**Waterfront Construction, Inc.**  
205 NE Northlake Way, Suite 230  
Seattle, WA 98105-6816  
Tel (206) 548-9800 Fax (206) 548-1022  
Contractor's License # WATECI881RS

**Doug Rosen - Dock and Pile Repair**  
**WCI Response to SHL21-002 / SEP21-002 4th Review Letter**

PROPOSED: PIER REPAIR
PURPOSE: RESTORE PIER INTEGRITY
DATUM: C.O.E. MLLW=0.0'

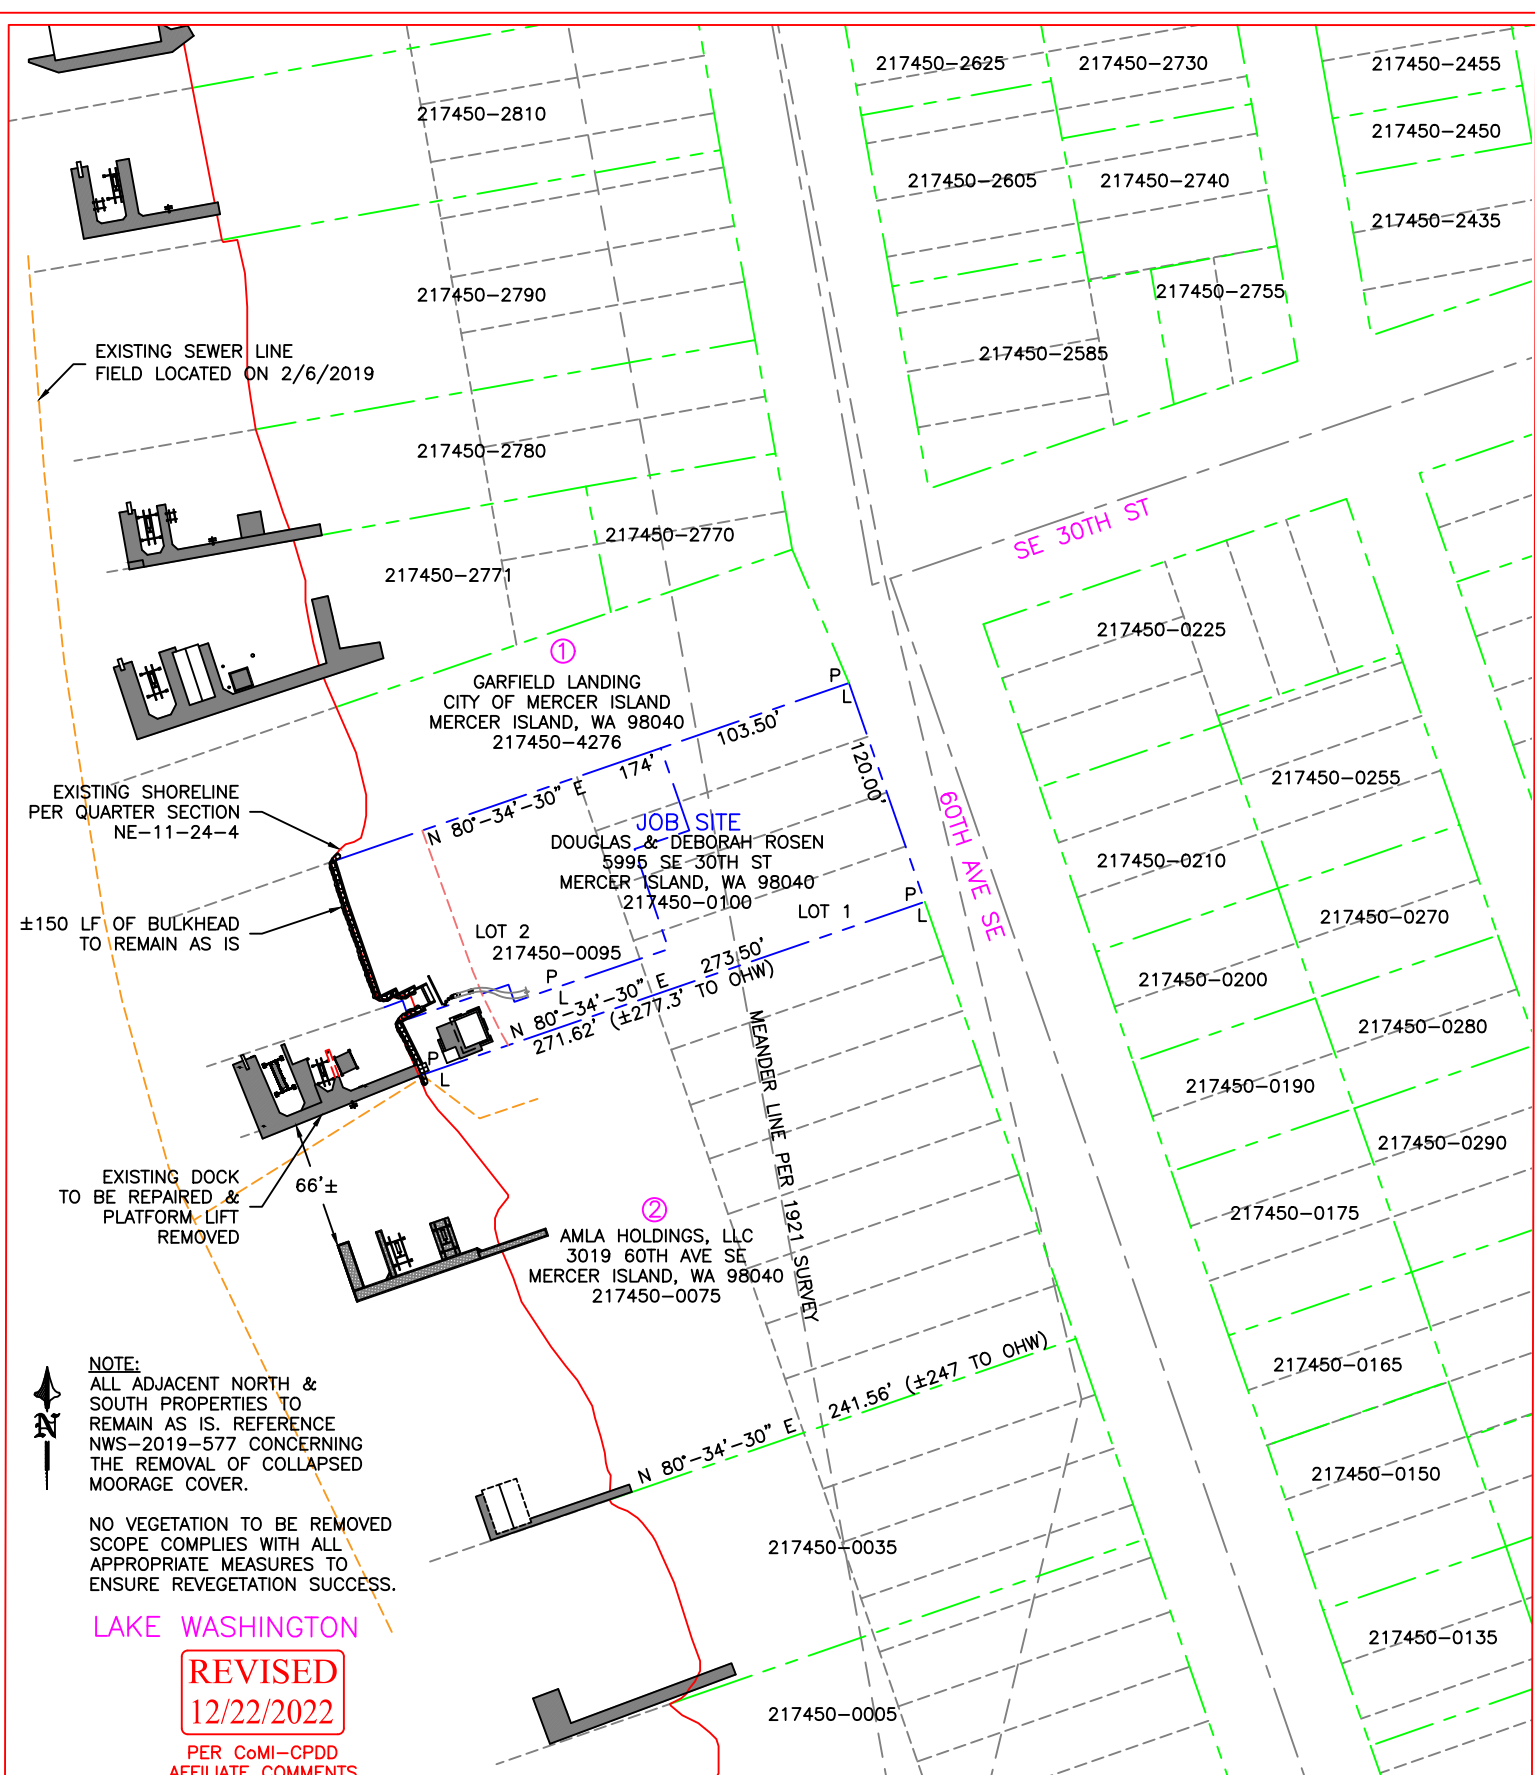
3. The first submittal of this permit included an affidavit stating that the sewer lake line was field located at this site. However, the plans state that the location of the sewer lake line will be field verified prior to building permit approval. Please clarify this discrepancy and show the field-verified location of the sewer lake line and its associated easement on the plans.

WCI response: Plan set has been revised to include field-located sewer line on 2/6/2019.

REFERENCE #:		
APPLICANT: DOUGLAS ROSEN		
PROPOSED: PIER REPAIR		
SHEET: 2	OF: 16	NEAR/AT: MERCER ISLAND
DATE: 2-7-2020	DWG#: 19-31042-A13-2

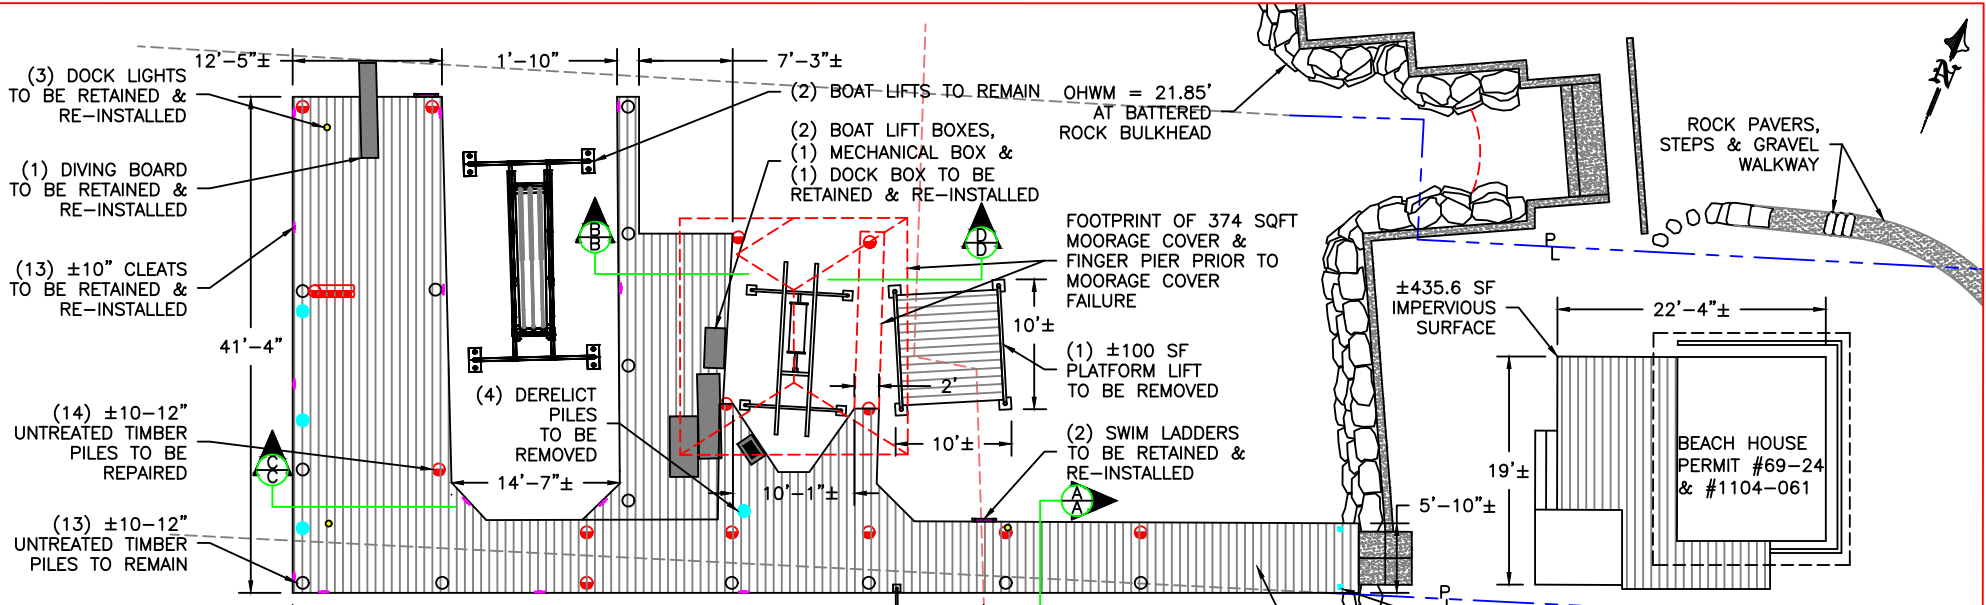
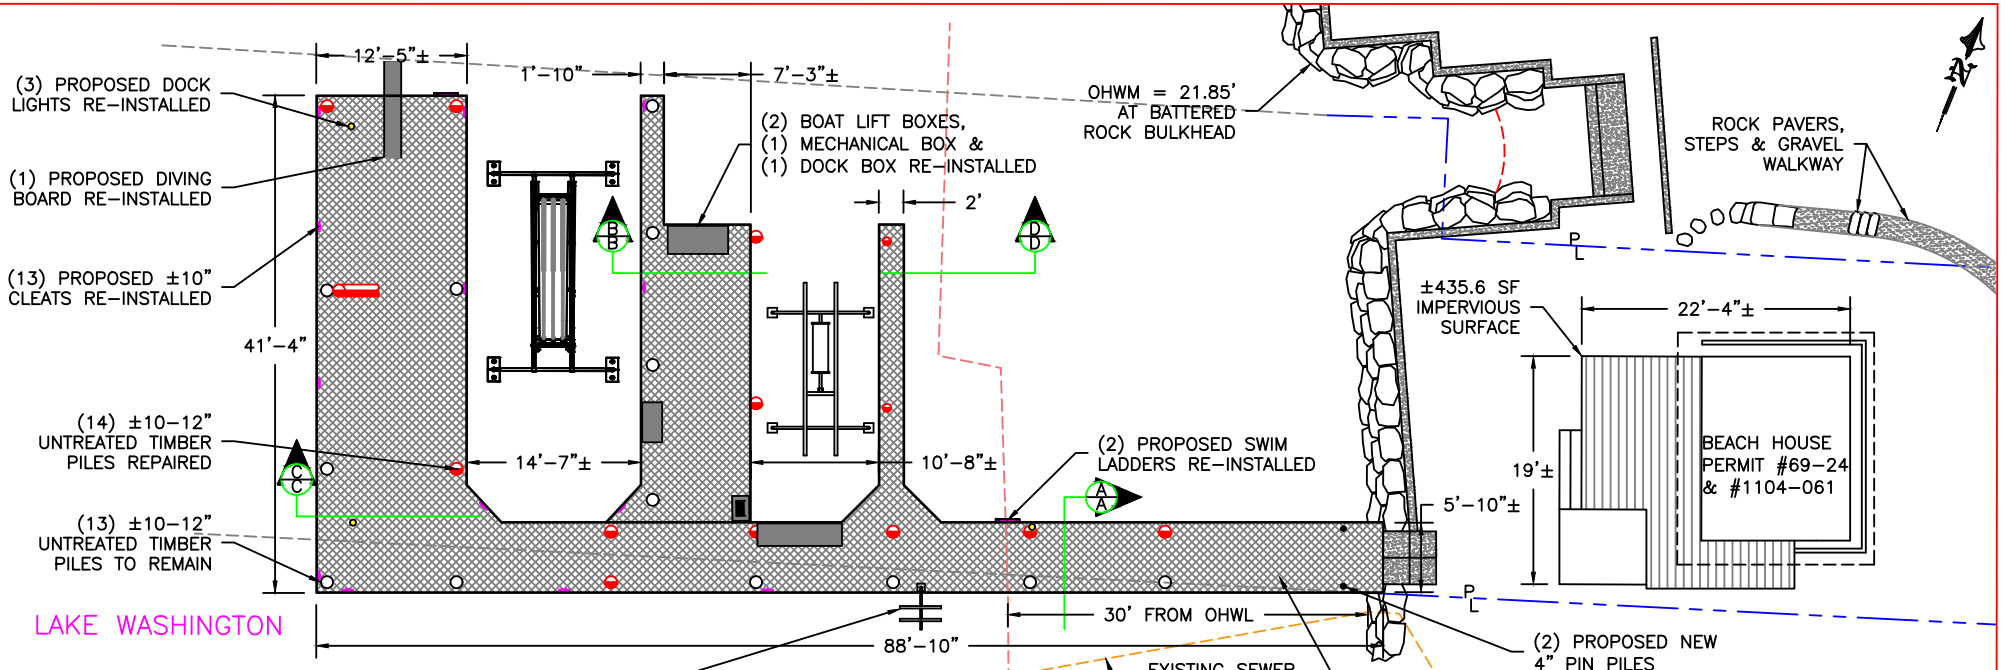
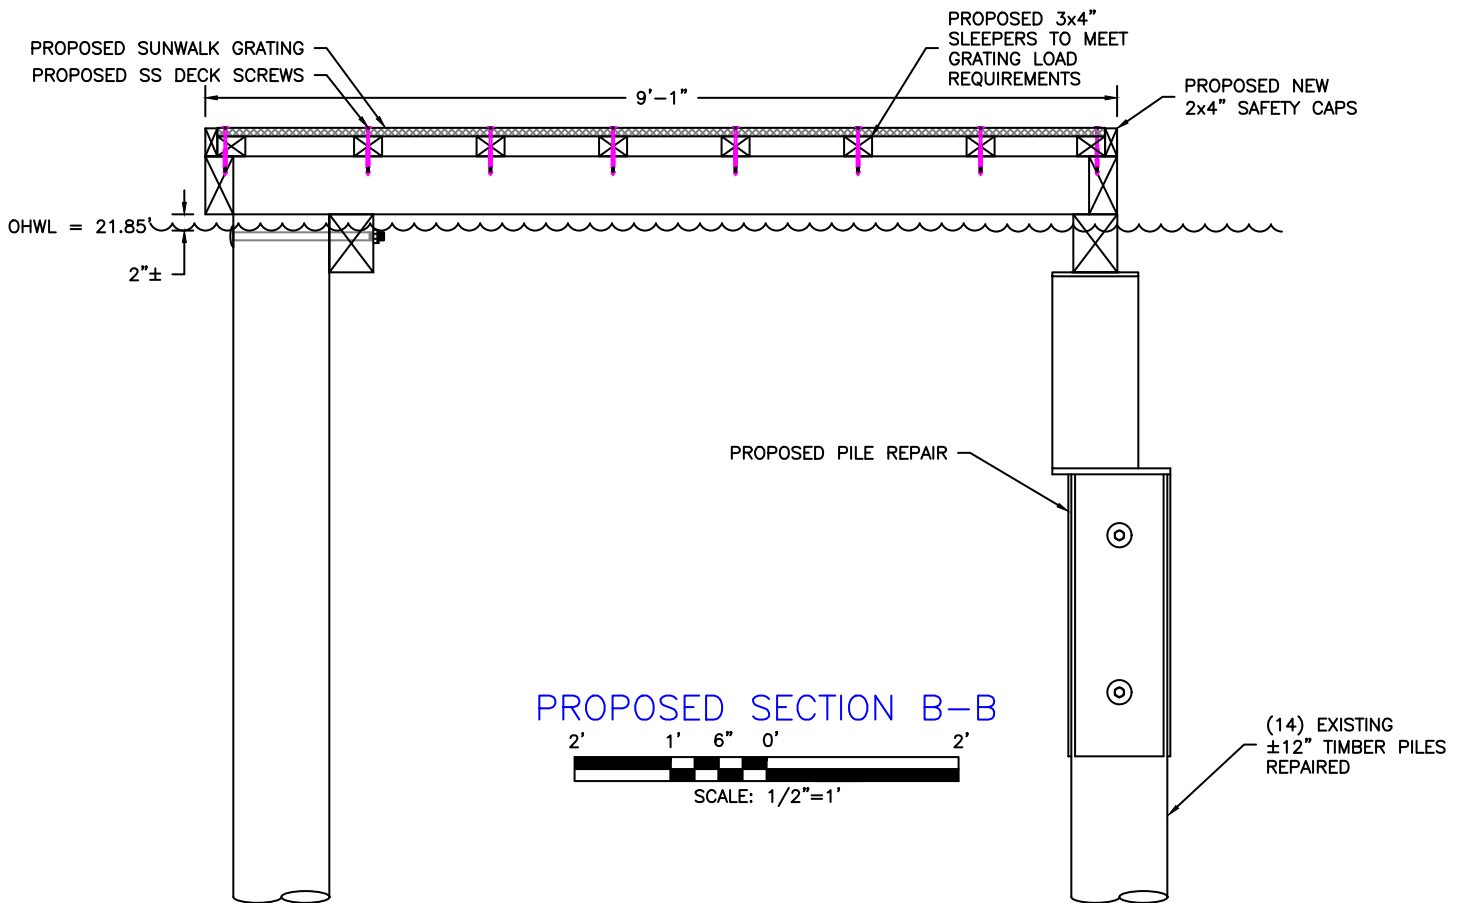
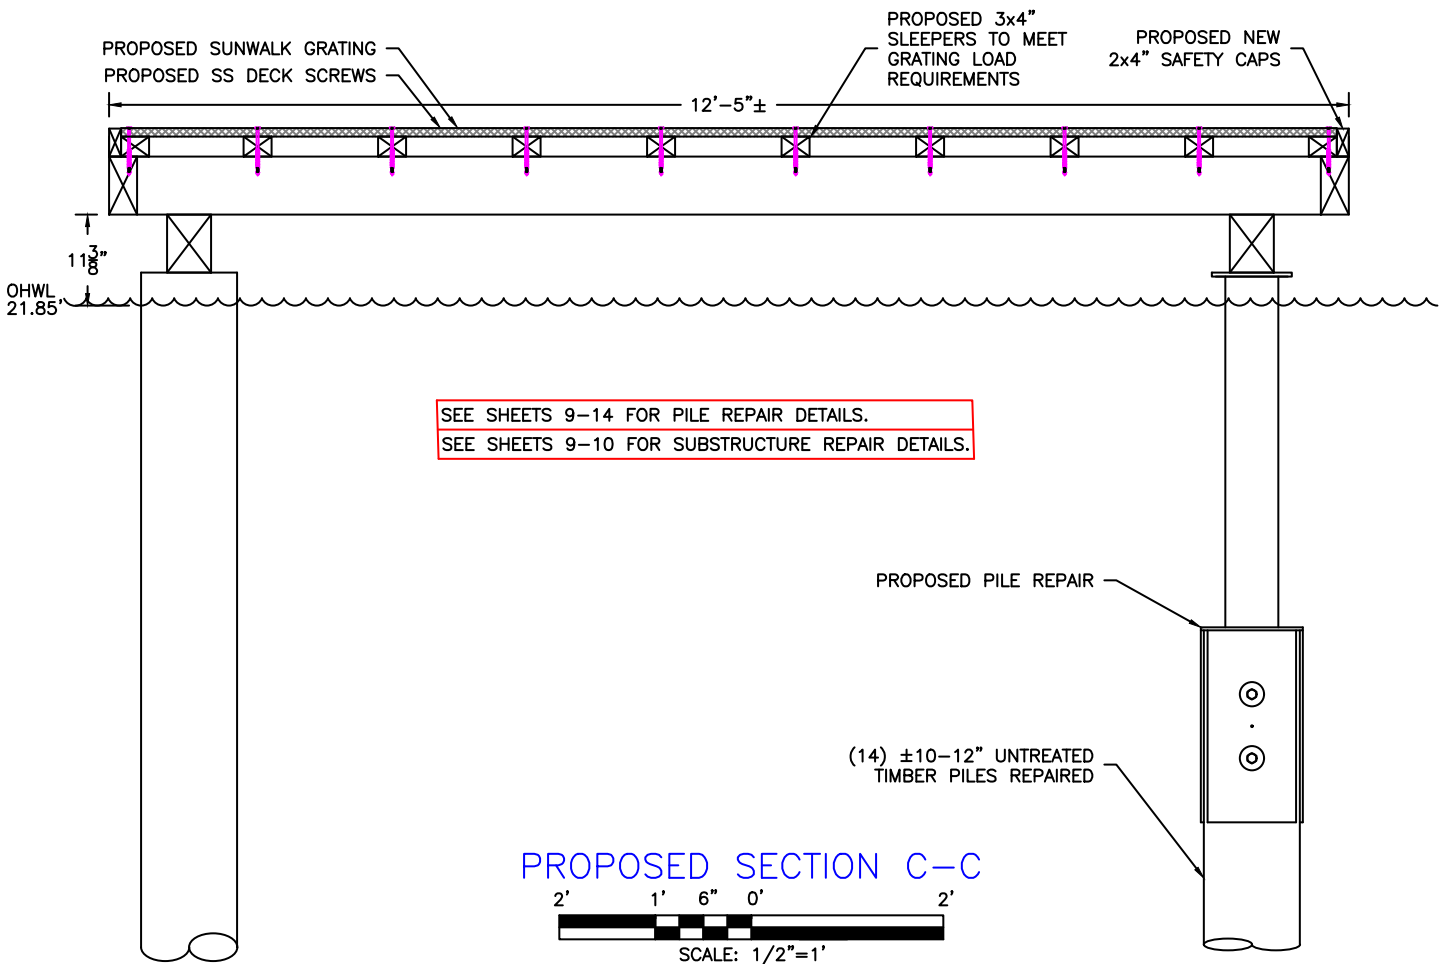
- MICC 19.13.050(F)(2)(ii) requires that the area, width, and length of the moorage facility cannot be increased, but may be decreased. The plans show that the width and height of the pier are proposed to be increased. Please revise the proposed width and height of the pier so they are not increased.

WCI response: Plan set has been revised to retain original area, width and length. Proposed maximum heights do not exceed existing dimensions. Please see plan set for details or contact Mark Kushino (206/407-5859 [mark@waterfrontconstruction.com](mailto:mark@waterfrontconstruction.com)) for further clarification.
